**WEST SUSSEX COUNTY COUNCIL
PLANNING SERVICES CONSULTATION**

SUBJECT: EP/138/17/PL - Demolition of existing buildings & erection of 3 no. dwellings with associated parking, alterations to existing access & relocation of staircase to flats.

Land Rear of Beechlands Cottages, Beechlands Close, East Preston, West Sussex, BN16 1JT

Proposed Site Plan, Block Plan
and Location Plan

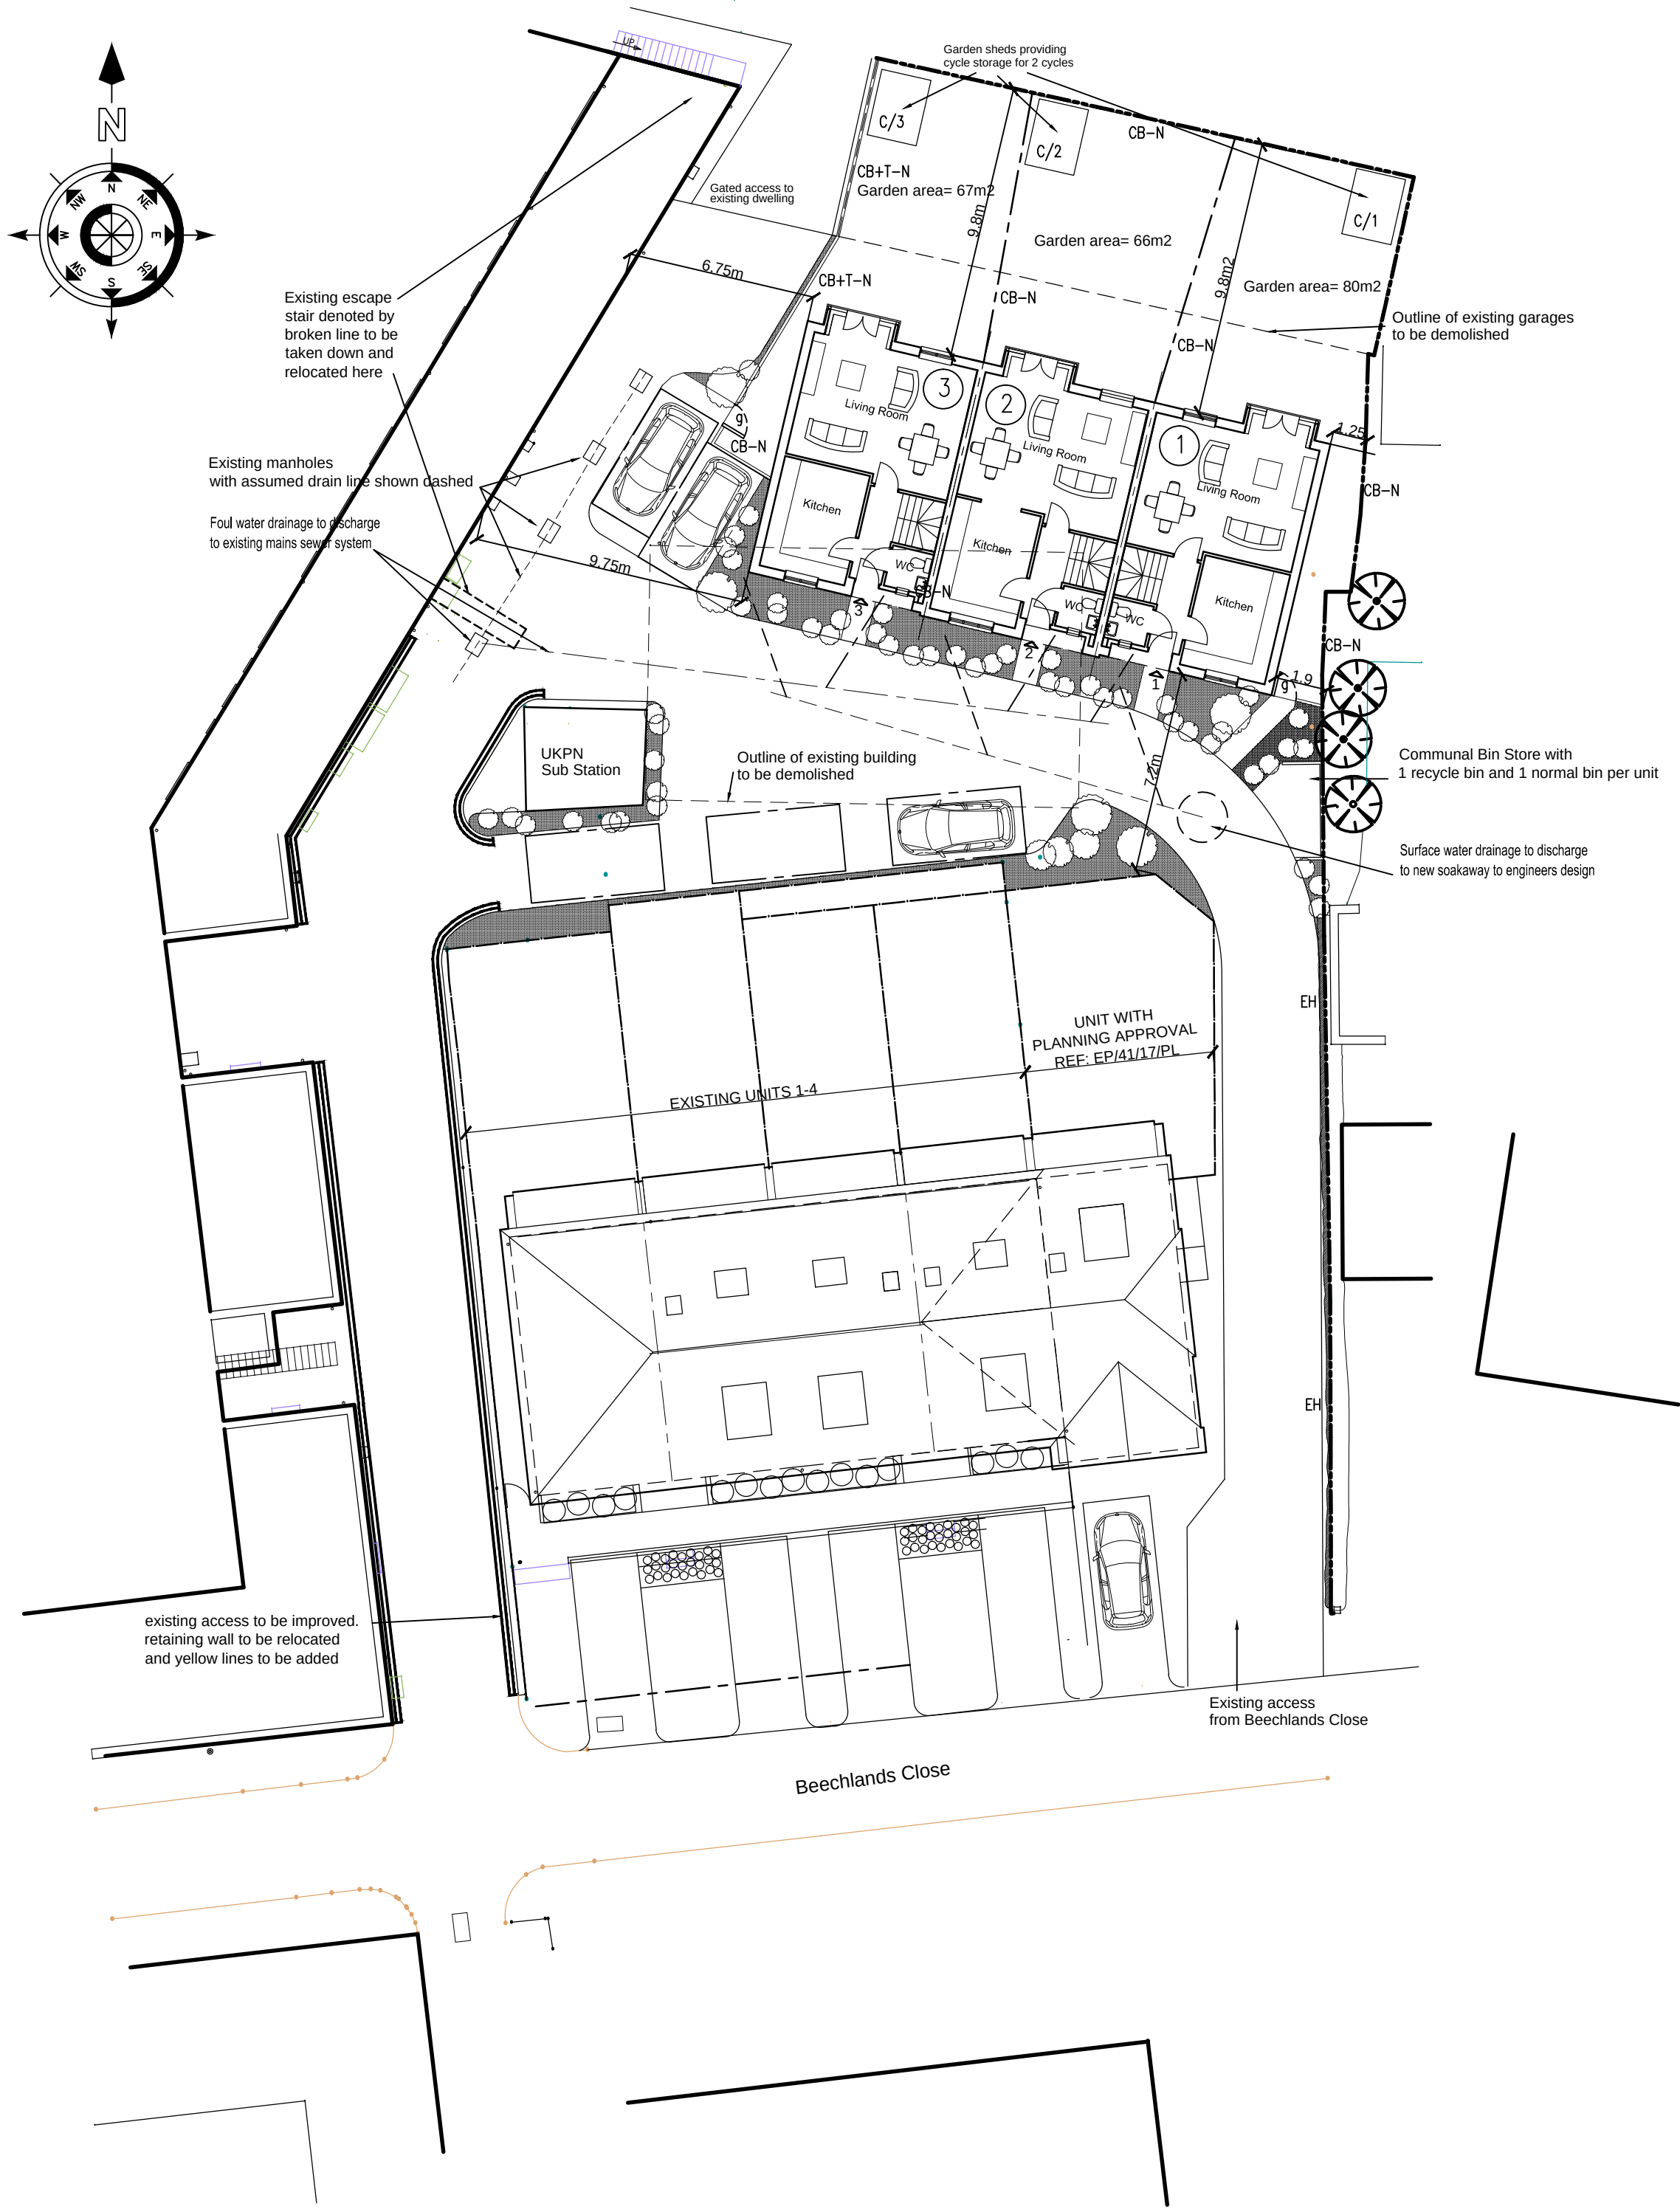
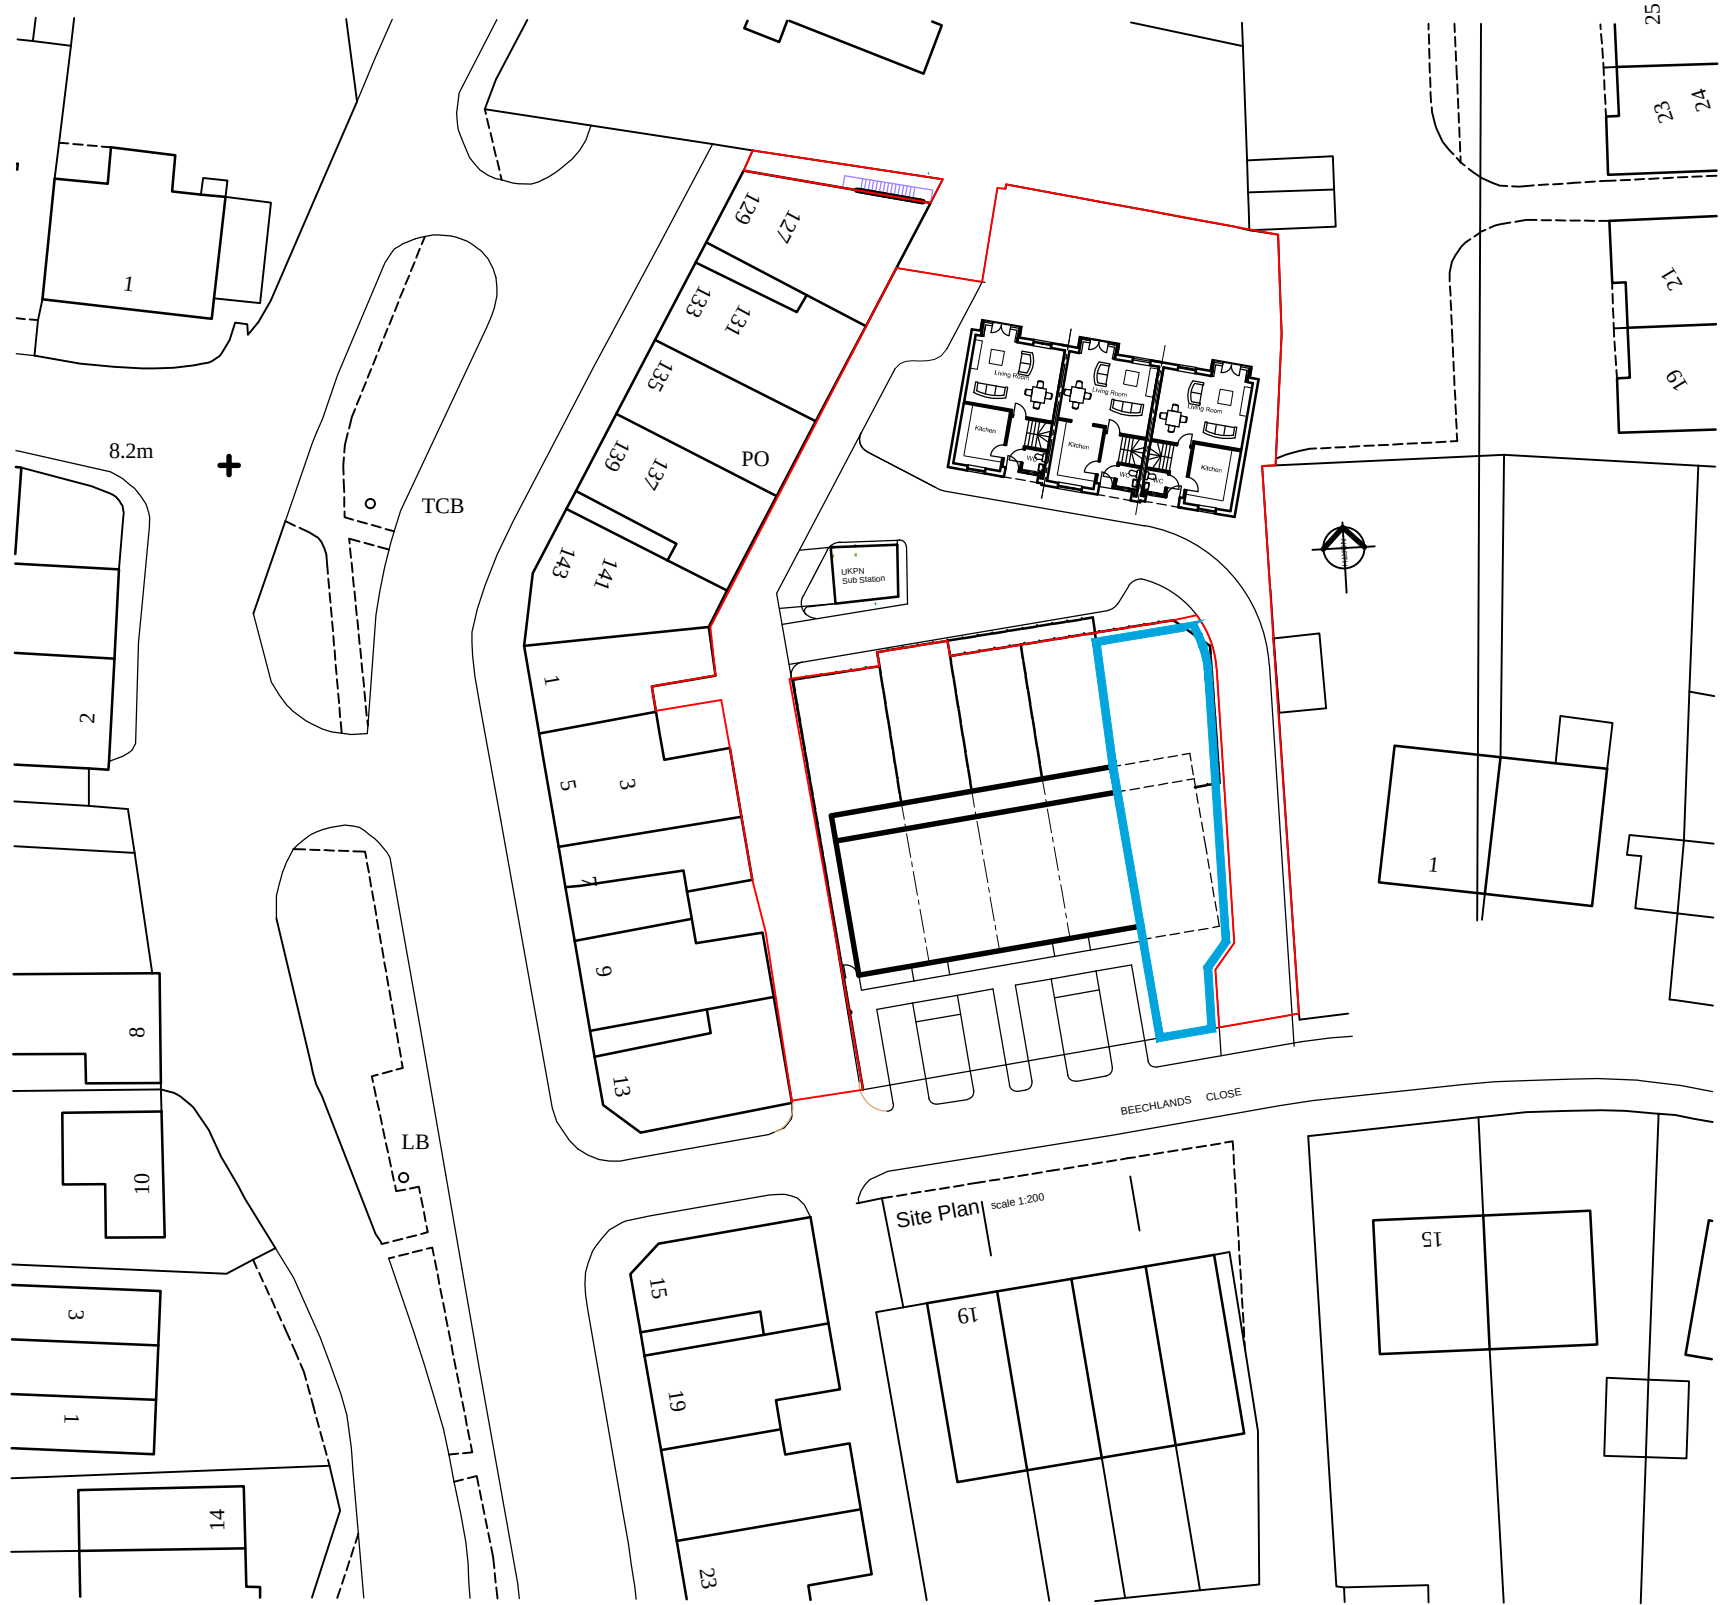
The existing access will be wide enough for two cars to pass at the entrance but narrows within the site. Considering the number of vehicle movements that could occur from the historic uses at the site the Local Highway Authority (LHA) would not substantiate a highway safety concern on these proposed access arrangements.

Five off street car parking spaces are proposed for the dwellings. The LHA question the workability of parking space immediately south of substation as this could not be accessed independently and exit to the west seems restrictive in width. Nevertheless, on the basis that the car parking spaces remain unallocated the parking demand for a development of this scale and location would be 4 x spaces and therefore whilst the applicant may wish to consider the practicality of these arrangements the LHA would not raise any safety or capacity concerns.

Cycle Stores

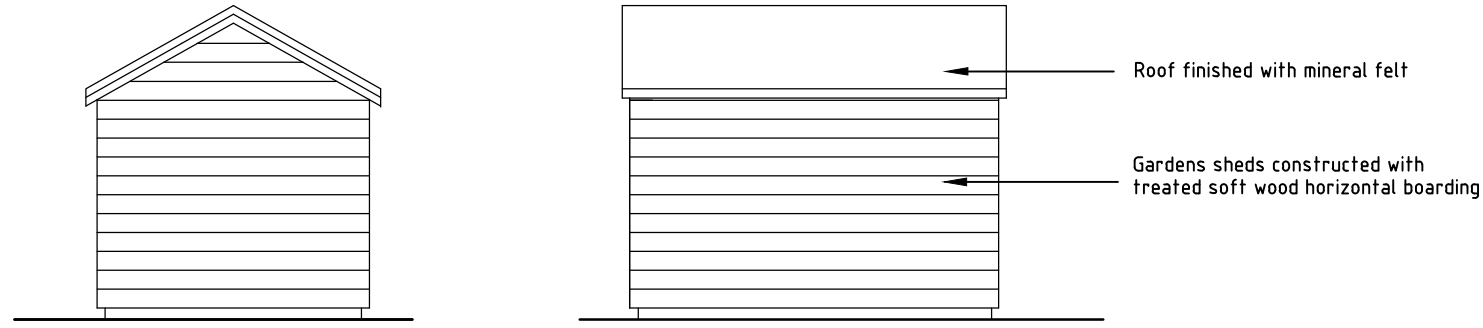
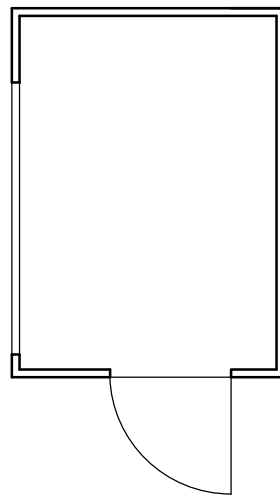
The site is in close proximity to a range of shops, local services and amenities as well as within walking distance of bus stops providing an option for sustainable modes of transport to be up taken. Secure and covered bicycle storage will be provided and this should be maintained in perpetuity.

No part of the development shall be first occupied until covered and secure cycle parking spaces have been provided in accordance with the approved plans.
